**RE: Response to Modification of SSD 8517 – Innovation Plaza Locomotive Workshops (MOD 7)**

Thank you for inviting the Heritage Council of NSW (email 15 December 2020) to provide advice on the above Modification Request relating to the Locomotive Workshops.

28 January 2021

1 L0 PLAN EXTRACT - INNOVATION PLAZA NORTH
1 : 150

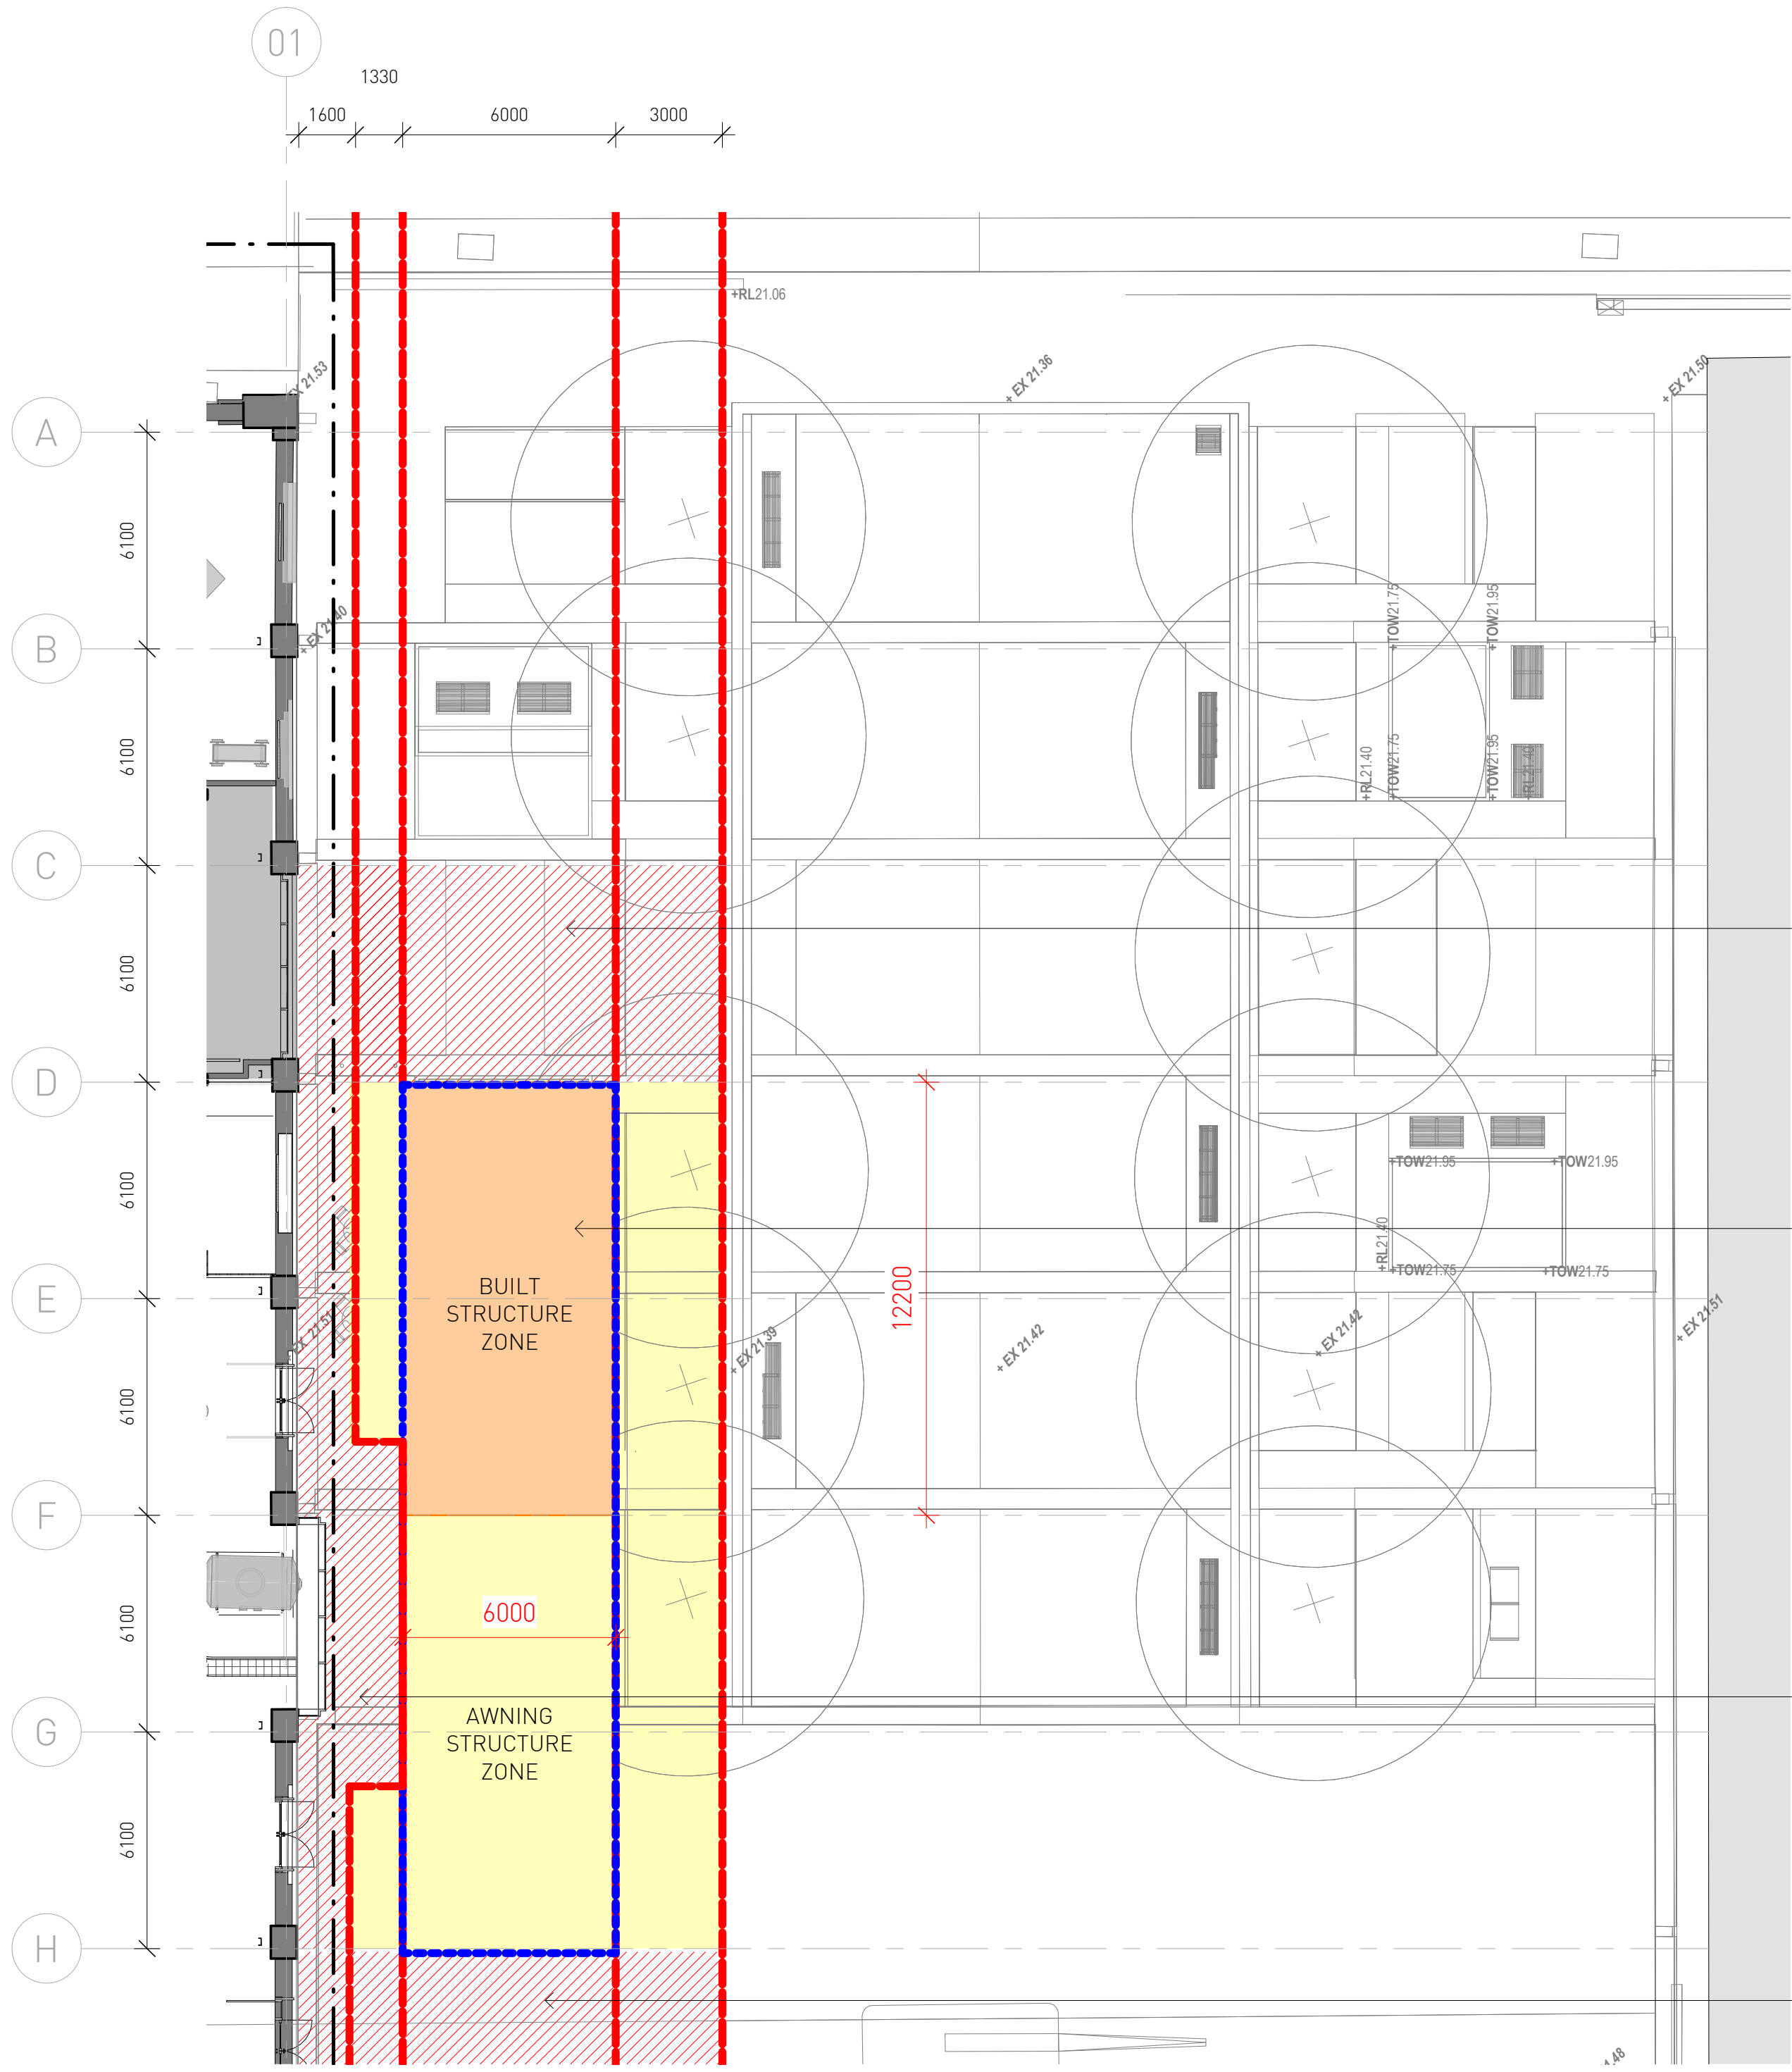
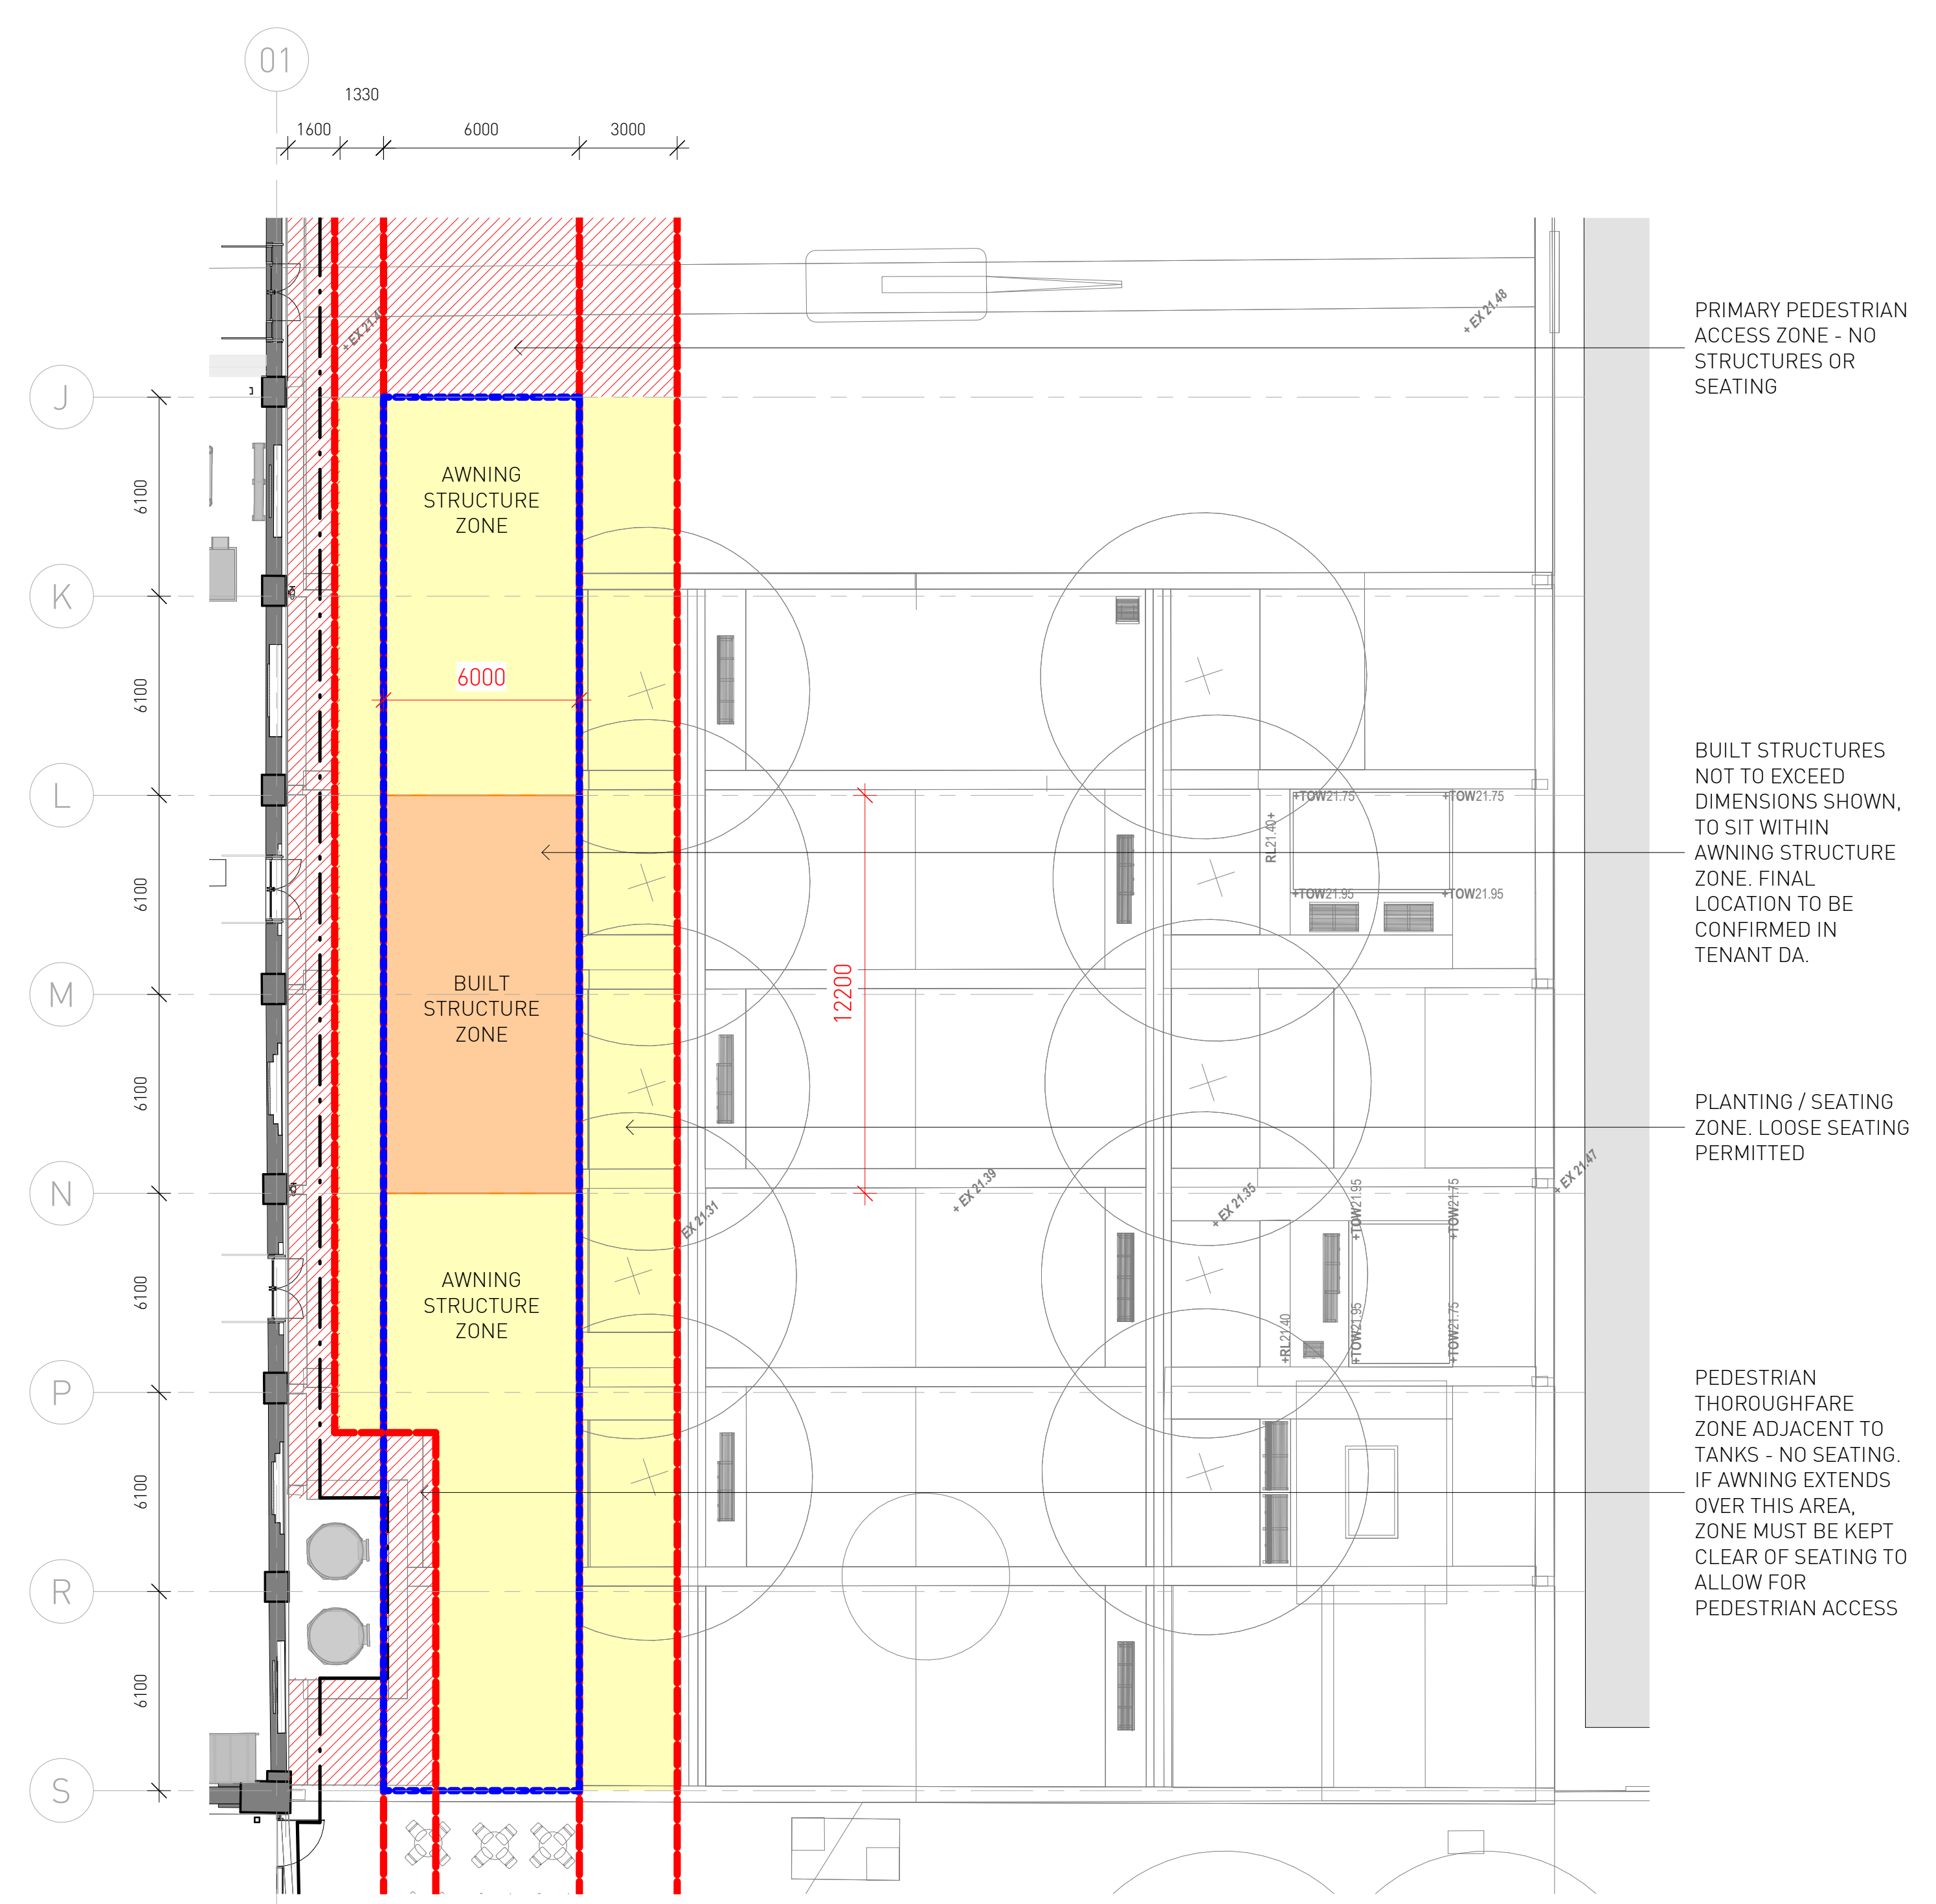
We generally support the use of the western portion of Innovation Plaza as retail premises as it would allow engagement and interaction with the existing heritage buildings. We also do not have objections in expanding the approved outdoor seating areas provided legibility of Locomotive Workshops building and its distinctive elements are not compromised. However, we recommend that the proposed 1.6m separation between the building and the seating be increased to 2 metres to provide a more appropriate physical and visual separation and better pedestrian movement in that area.
